COMMUNITY SERVICES DEPARTMENT

December 8, 2021

Subject: Mayberry Filing No.1 Replat (VR 2113)

The Community Services Department has reviewed the development application for Mayberry Filing No.1 Replat and is providing the following final comments on behalf of El Paso County Parks.

# MAYBERRY, COLORADO SPRINGS FILING NO. 1A

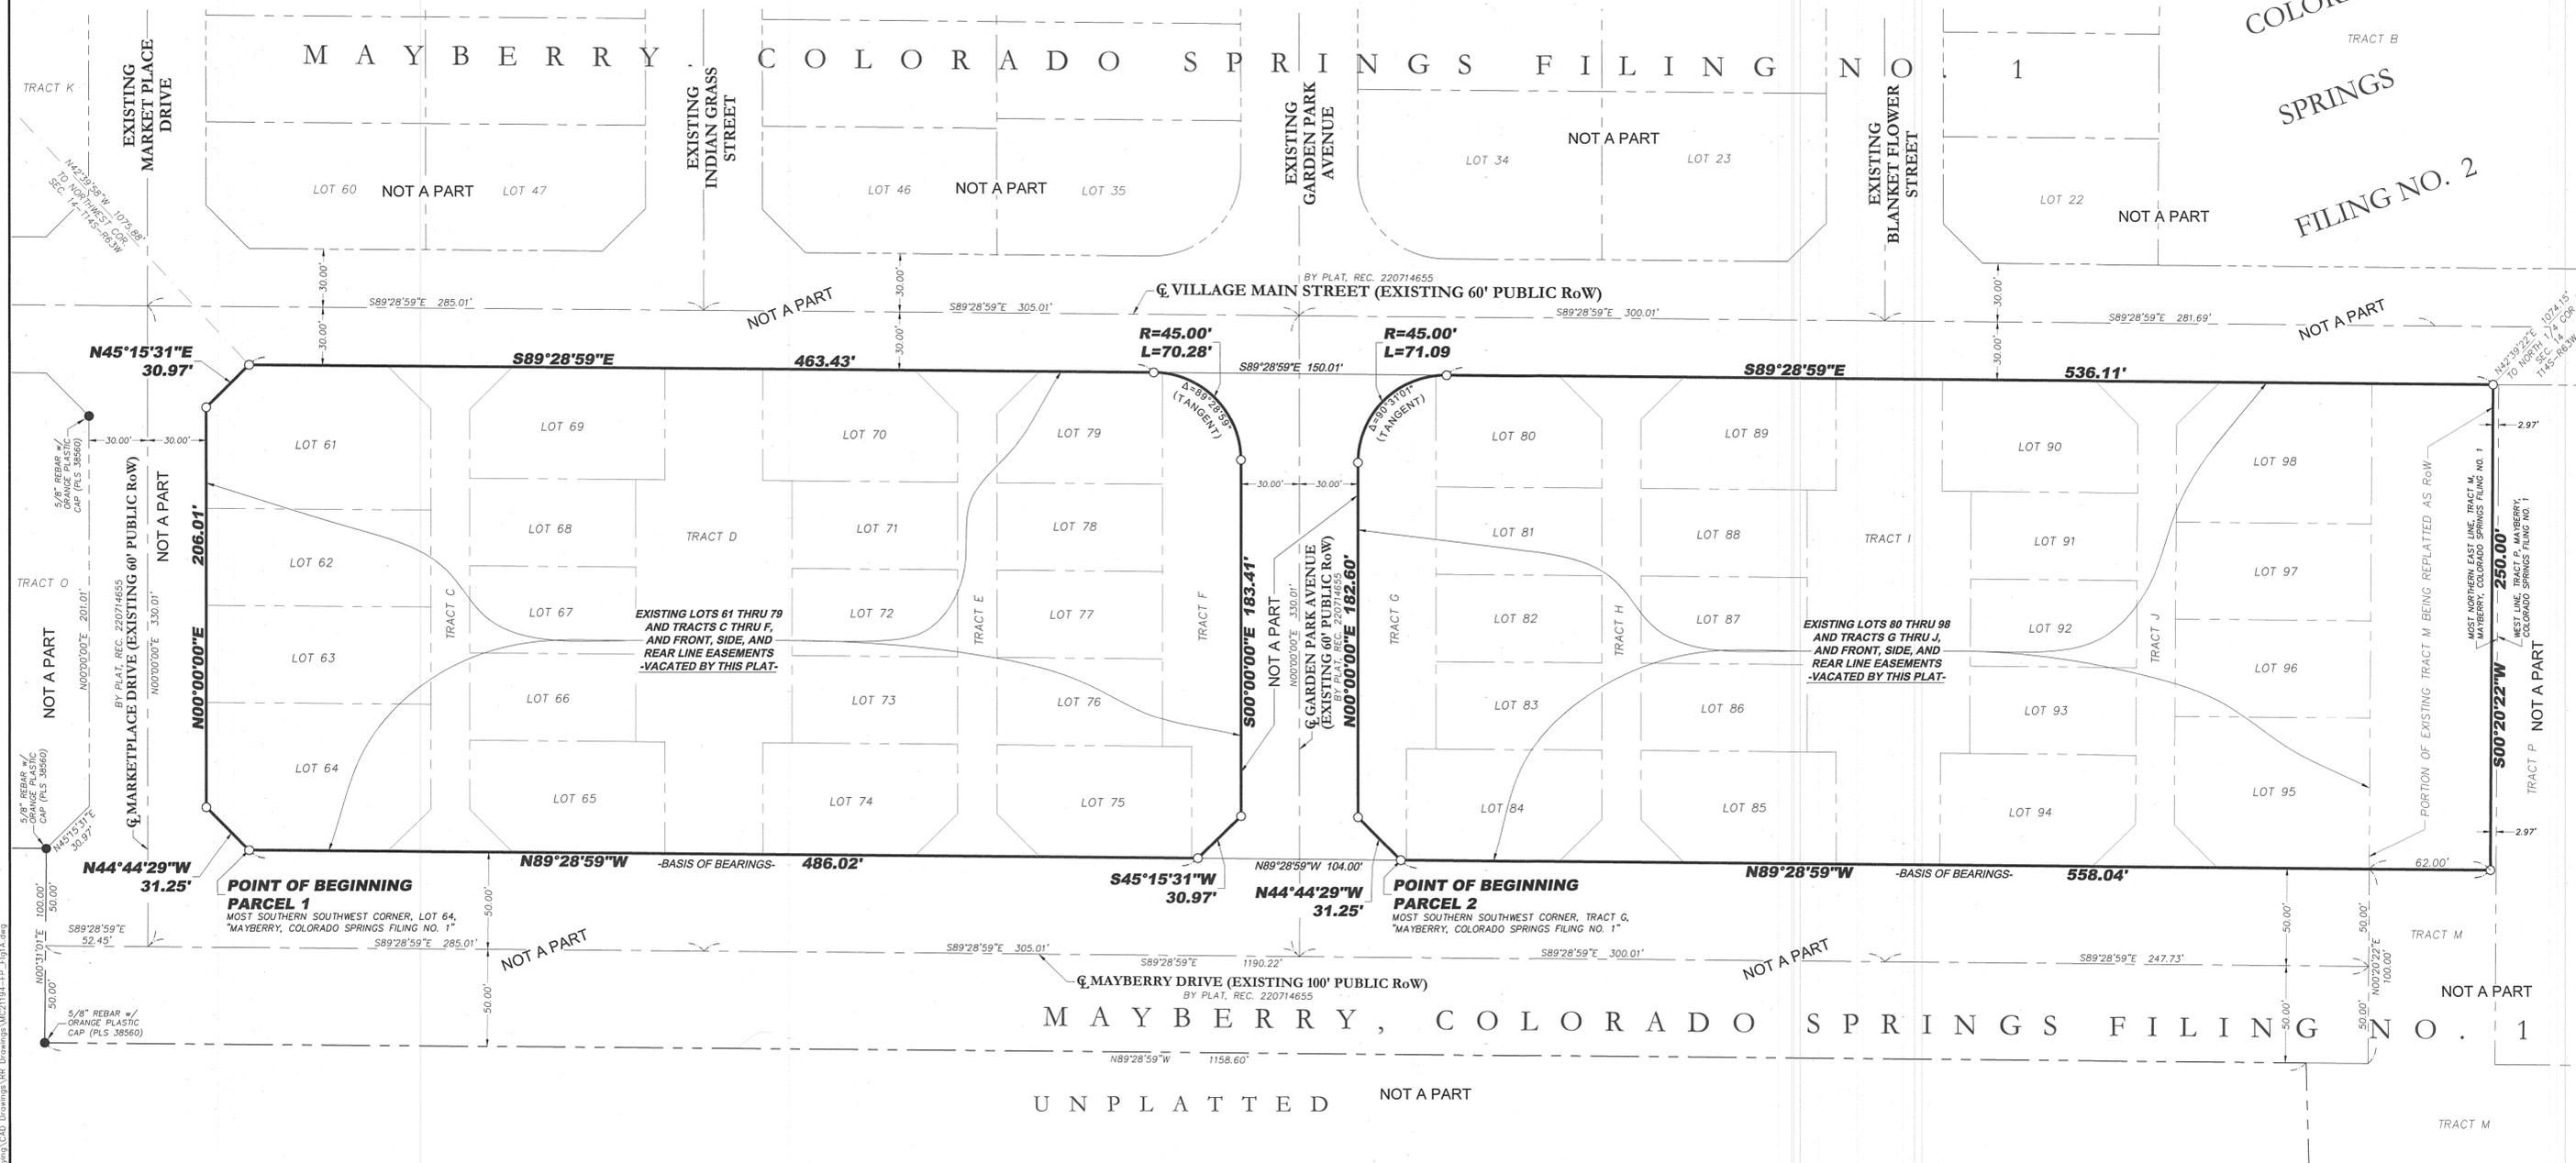
County Parks requests trail easements where development projects impact proposed County trails. As it pertains to this application, the County requests that the landowner provide a 25-foot public trail easement along the south side of Highway 94 that allows for the construction and maintenance by El Paso County of a Secondary Regional Trail, and this easement shall be shown and dedicated to El Paso County on the Final Plat.
